CITY OF ALBUQUERQUE

April 1, 2019

RE: 9050 Alameda Blvd NE
Grading and Drainage Plan Stamp Date: 2/20/19
Drainage Report Stamp Date: 2/20/19
Hydrology File: C20D077

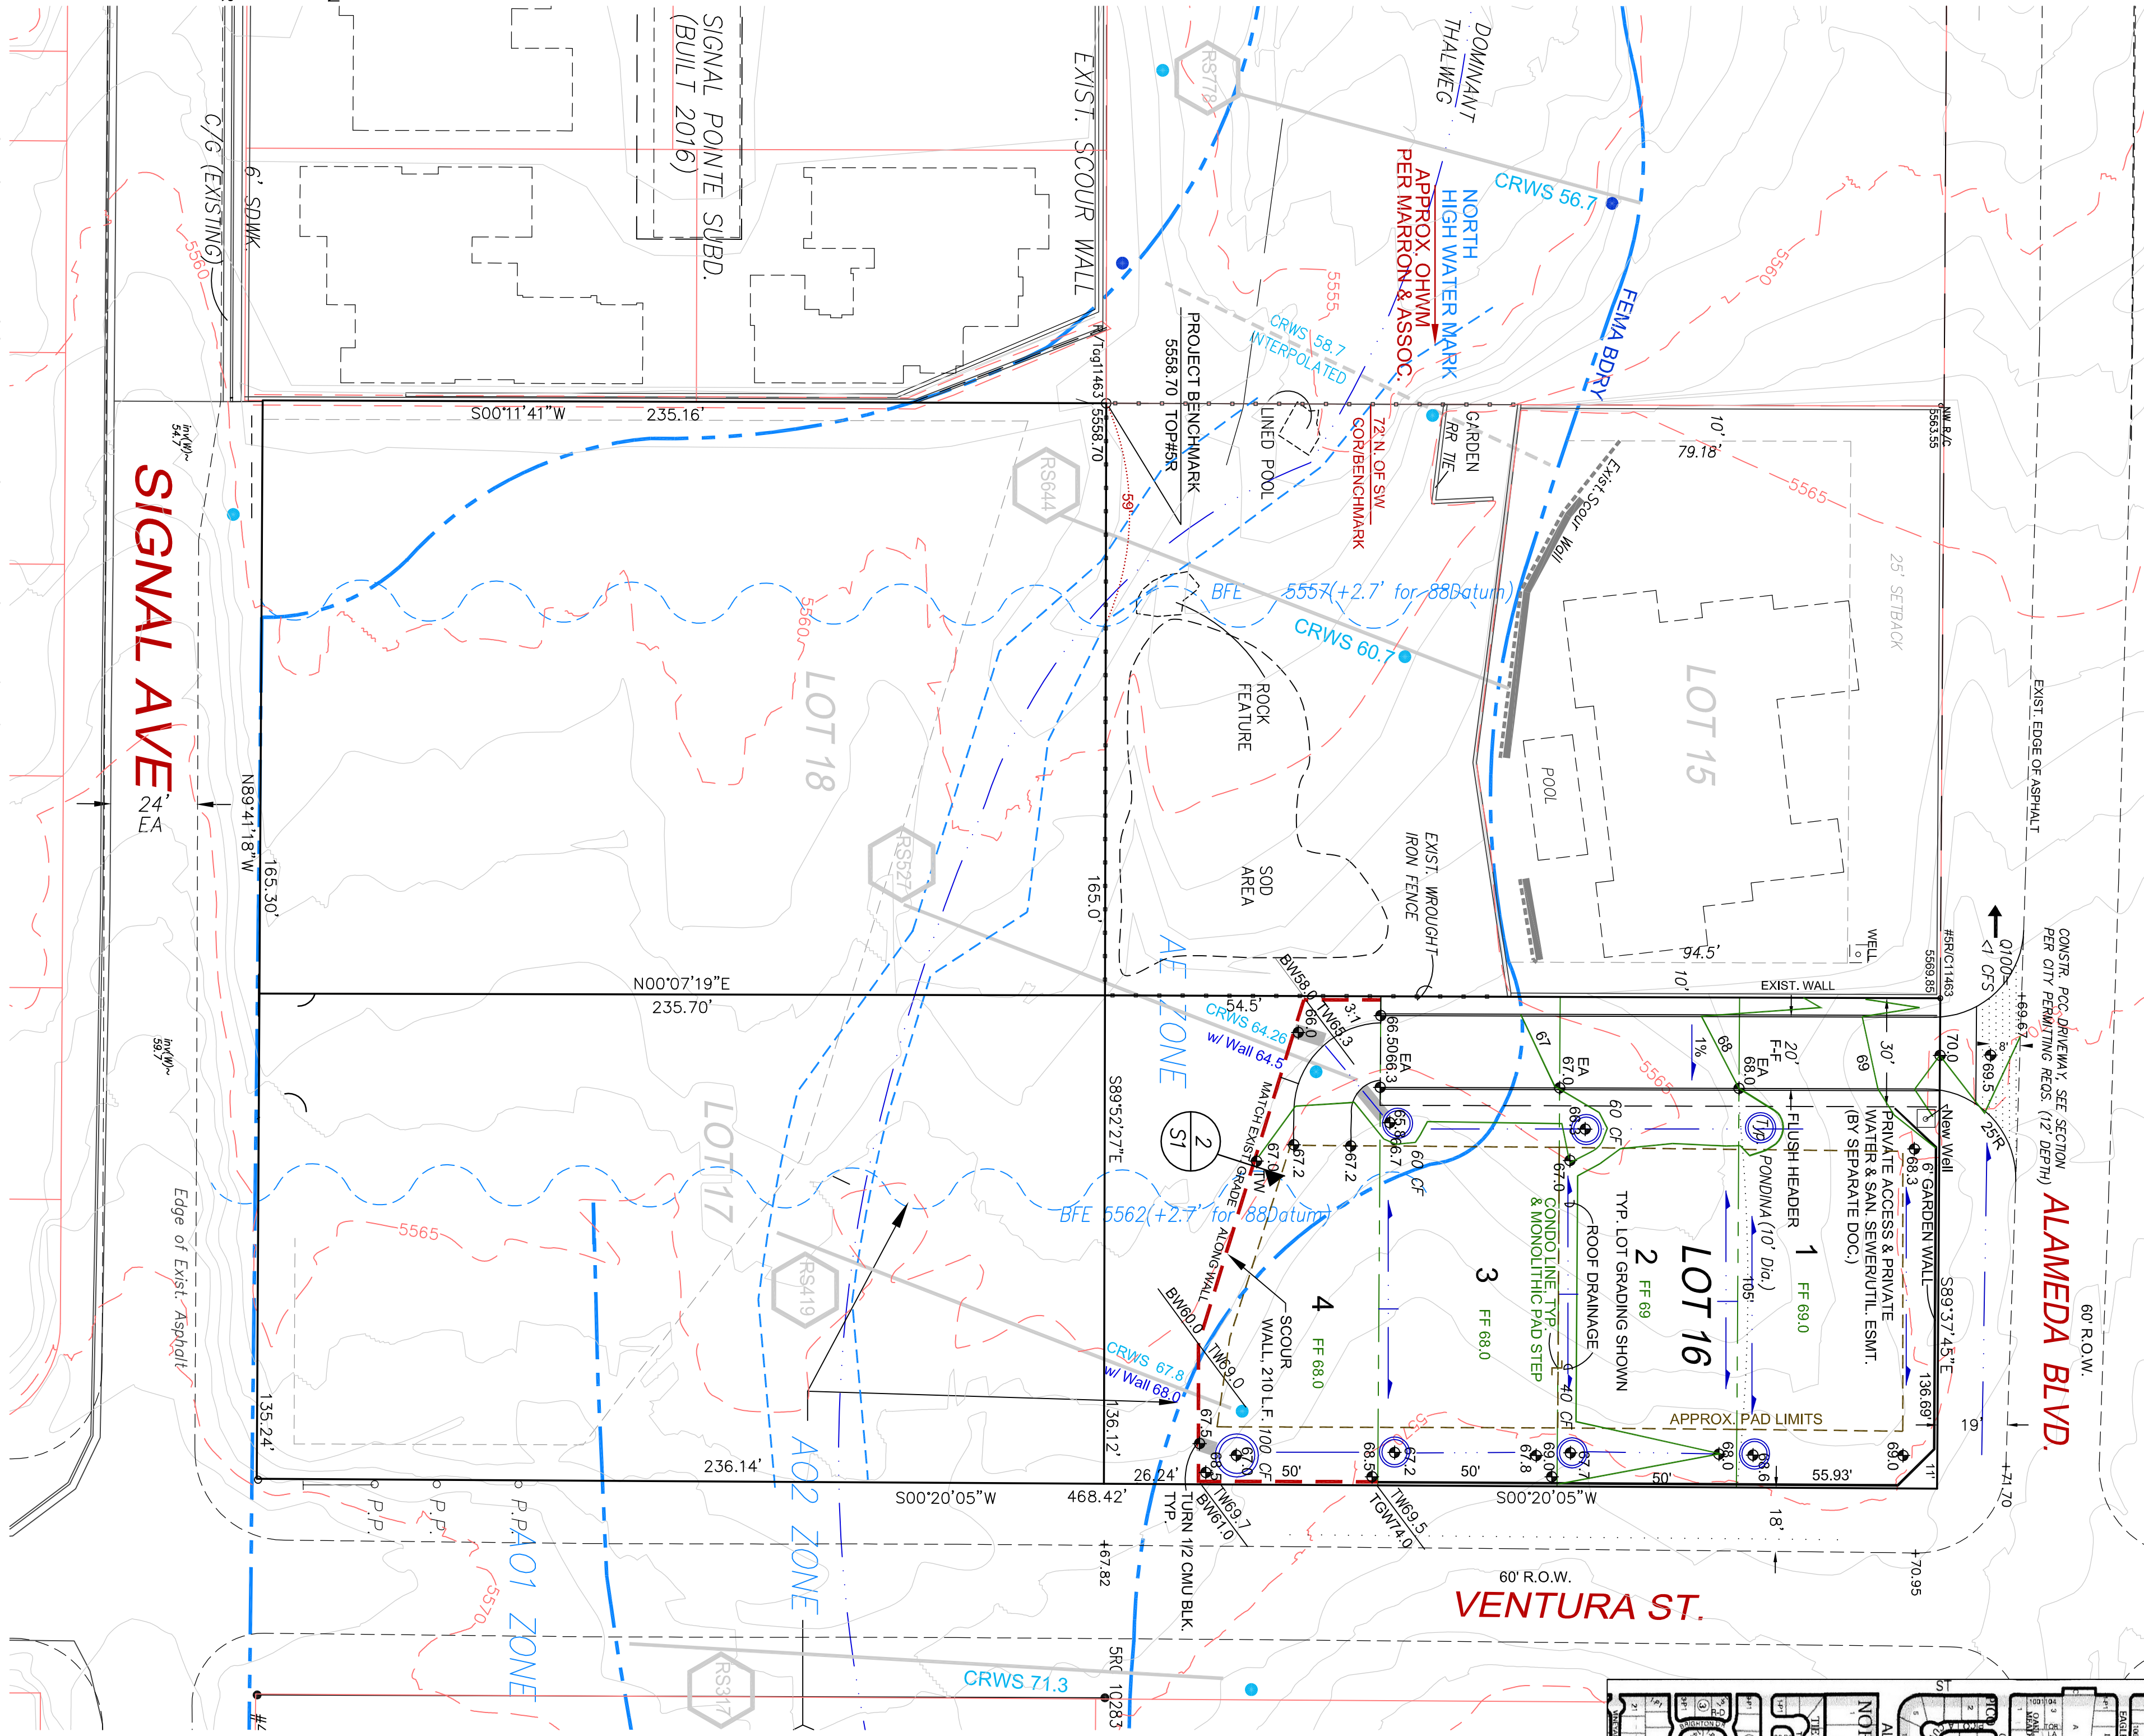
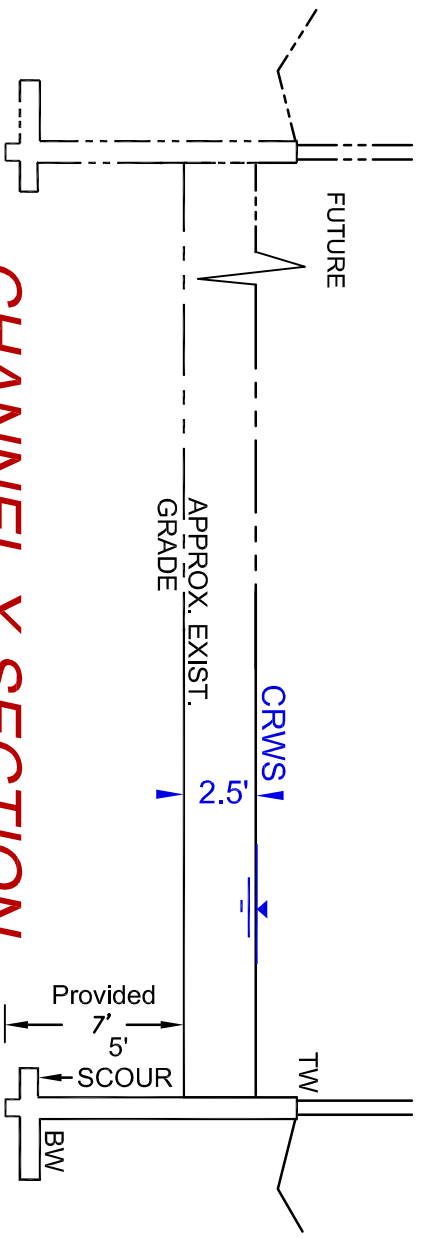
3. Identify all aspects of the arroyo treatment, and show them clearly on all exhibits.
 - a. Excavation is still shown on lot 15 in the HEC-RAS model even though grading is not shown on that lot on the G&D Plan. Will this development be relying on permission from the owner of lot 15 to

- iii. Construct grade control structures on lot 15
- iv. Any other impacts or construction on lot 15.
- b. Is the floodwall/ bank protection on lots 17 & 18 part of the infrastructure to be built by this project? It is shown in the HEC-RAS model but it is missing from the G&D Plan.

- c. Grade control structures will be required as part of this development if this development includes grading of the arroyo as shown on the G&D Plan and as modeled in the HEC-RAS. The natural braded arroyo is being replaced with a relatively clean straight channel where the supercritical flow regime is likely and sediment transport rates may significantly exceed the amount of sediment supplied from the natural braded channel upstream. The sediment transport calculations were missing from this report (include all calculations). Use subcritical results from the HEC-RAS to calculate the bed- load transport rate east of Ventura and compare to normal depth calculations for the typical channel ($n=0.02$) and equilibrium slope (about 0.2%) next to this development and the existing subdivision to the west. Use a consistent partial size for all calculations. Typical sections used in the calculations must agree with the typical sections shown on the G&D Plan.

- iv. The grades in the Proposed HEC-RAS model at section 1527 are different than what is shown on the grading plan. Both the grading plan and the HEC-RAS section must be fixed to show the grades in

- b. Layout the scour/floodwalls, easements, and property lines on the G&D Plan to clearly demonstrate that the footings are contained in the easements and do not encroach into the right of way. Either layout all of the footers or just use the largest footer to dimension between the wall and the easement and property lines.

- a. Differentiate between existing conditions (dashed line type) proposed by this development (solid line type) and future development (screened line type) and identify phasing of the improvements if necessary on the G&D Plan.

- b. Show the scour wall and the easement line on the G&D Plan. Either show the footer or a dimension between the wall and the easement that will contain the widest footer.
